Drawing Status	FINAL	
Scale @ A3	1:10,000	DO NOT SCALE
JACOBS No.	32108600	
Client No.		
Drawing No.	ML1-JAI-EIA-ROUT_XX-DR-Y-14009	Rev P02

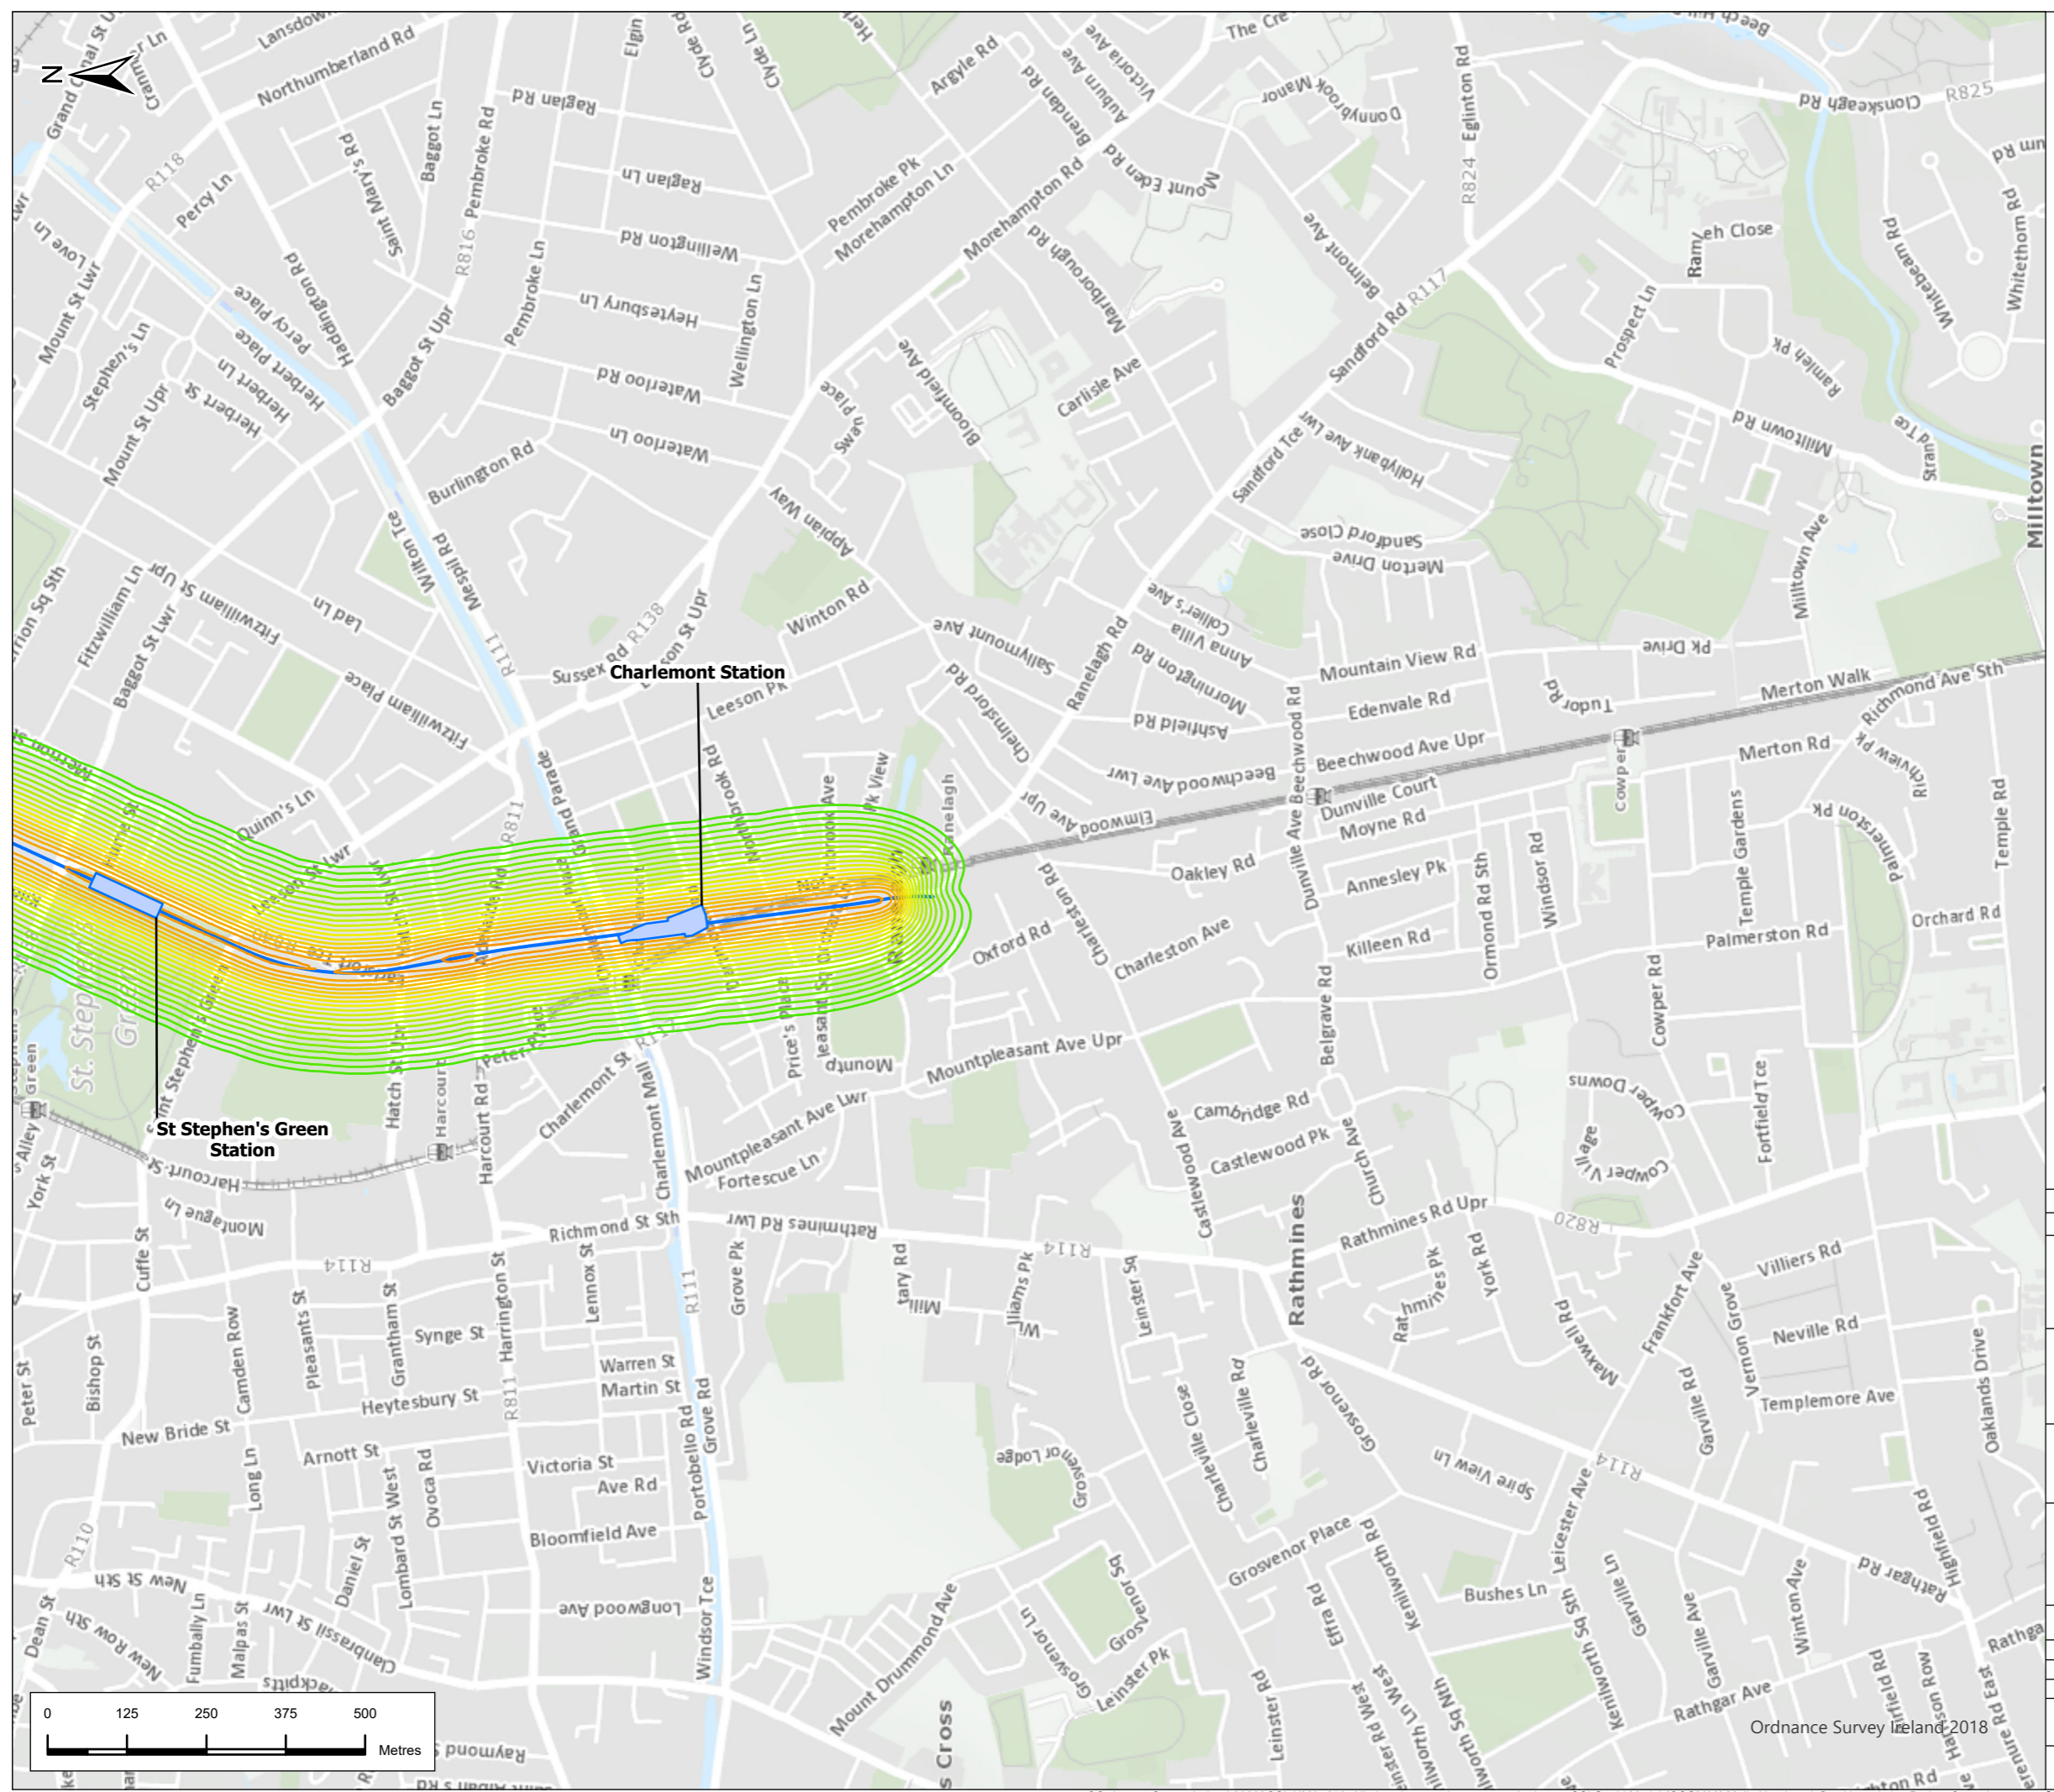
3	Part 2 - Construction Information	3	<p>a) MetroLink has assessed the "Ground Borne Noise from Tunnel Boring Machine" and presents its findings on Drawing No. ML1-JAI-EIA-ROUT-XX-DR-Y-14009 (a copy is attached to this submission). This drawing indicates MetroLink will generate an additional 50db directly under the location of our Clients' building, which is unacceptable.</p>	<p>Appendix 14.5 Ground Borne Noise and Vibration Blasting Modelling Results presents predicted groundborne noise and vibration levels during the construction and operation phase of the project. The prediction of groundborne noise during TBM passage for the Earl Court Apartments is 50 dB LASmax, which is above the 45 dB LASmax threshold, resulting potential for impacts on the buildings occupants for the limited duration of TBM passage (less than 2 weeks). Unfortunately, there are no effective methods available to reduce groundborne noise or vibration from TBMs at source, but noting that the duration of this impact will be in the order of up to two weeks as the TBM passes. TII will liaise with Earl Court Management Company DAC to ensure the timing of these impacts are known.</p> <p>The principal mitigation measures aimed at minimising impacts are as follows:</p> <ul style="list-style-type: none">- Advance public consultation and stakeholder engagement can greatly reduce the significance of groundborne noise effects, as building occupants would be prepared for the passage of the TBM and resultant elevated noise and vibration levels.- TII will accept and consider applications for additional measures on a case-by case basis, in accordance with its Noise and Vibration Mitigation Policy (see EIAR Appendix A14.6, Airborne Noise & Groundborne Noise Mitigation Policy).

Drawing No.	ML1-JAI-EIA-ROUT_XX-DR-Y-14041	Rev	P02
-------------	--------------------------------	-----	-----

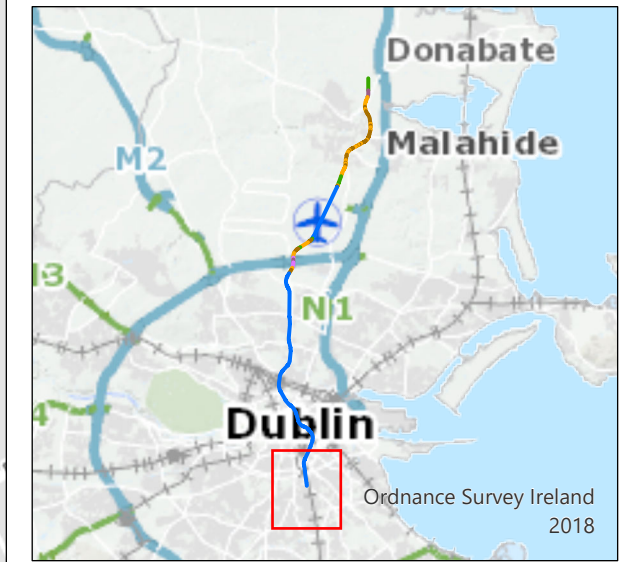
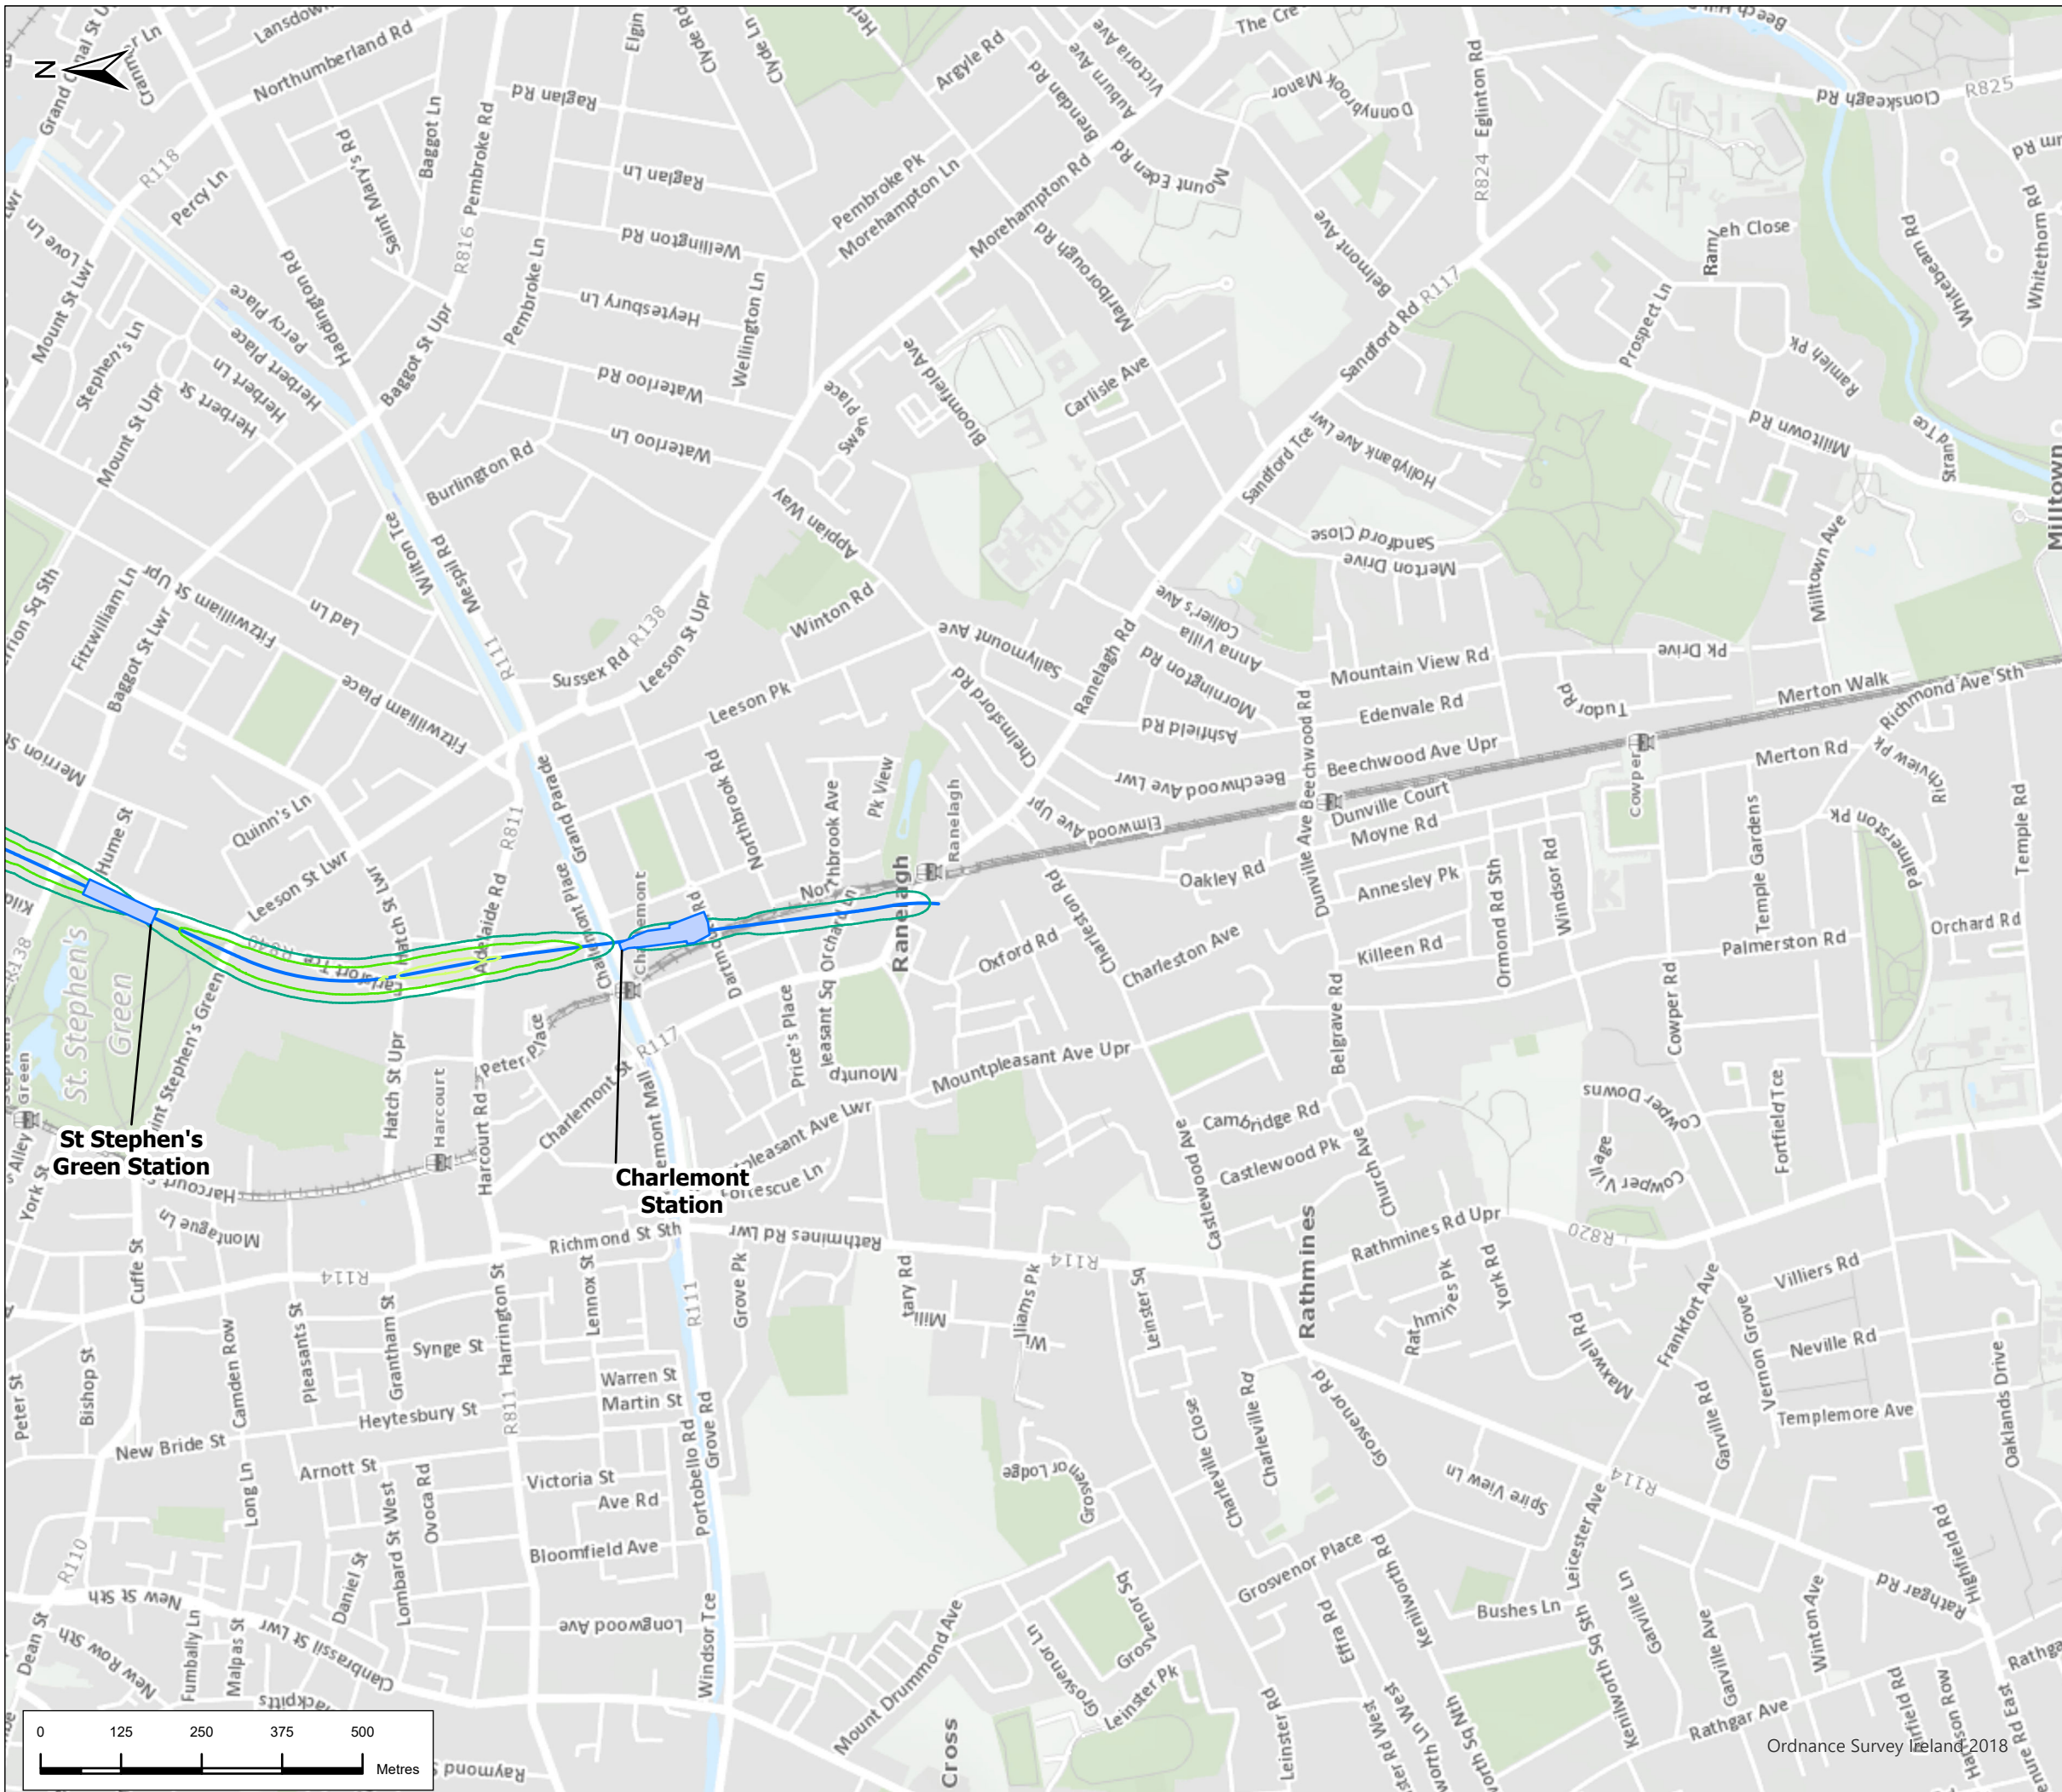
5	Part 3 - Operational Information	3	a) MetroLink has assessed the " <i>Groundborne Noise from Operation</i> " and presented its findings on Drawing No. ML1-JAI-EIA-ROUT-XX-DR-Y-14041 (a copy is attached to this submission). This drawing indicates MetroLink will be generating an additional 35db directly under the location of our Clients' building which is unacceptable.	Appendix 14.5 Groundborne Noise and Vibration Blasting Modelling Results presents predicted groundborne noise and vibration levels during the construction and operation phase of the project. For Earl Court Apartments building, the prediction of groundborne noise and vibration during railway operation are as follows: - The predicted level of groundborne noise during the railway operation for Earl Court Apartments building is 35 dB LASmax, which is below the 40 dB LASmax threshold. - The predicted level of groundborne vibration during the railway operation for Earl Court Apartments building is 0.01 ms-1.75, much lower than the VDV (Vibration Dose Value is a parameter that combines the magnitude of vibration and the time for which it occurs) threshold of 0.8 ms-1.75. As a result, we consider that no significant impact is expected on the building as a result of Metrolink operation.
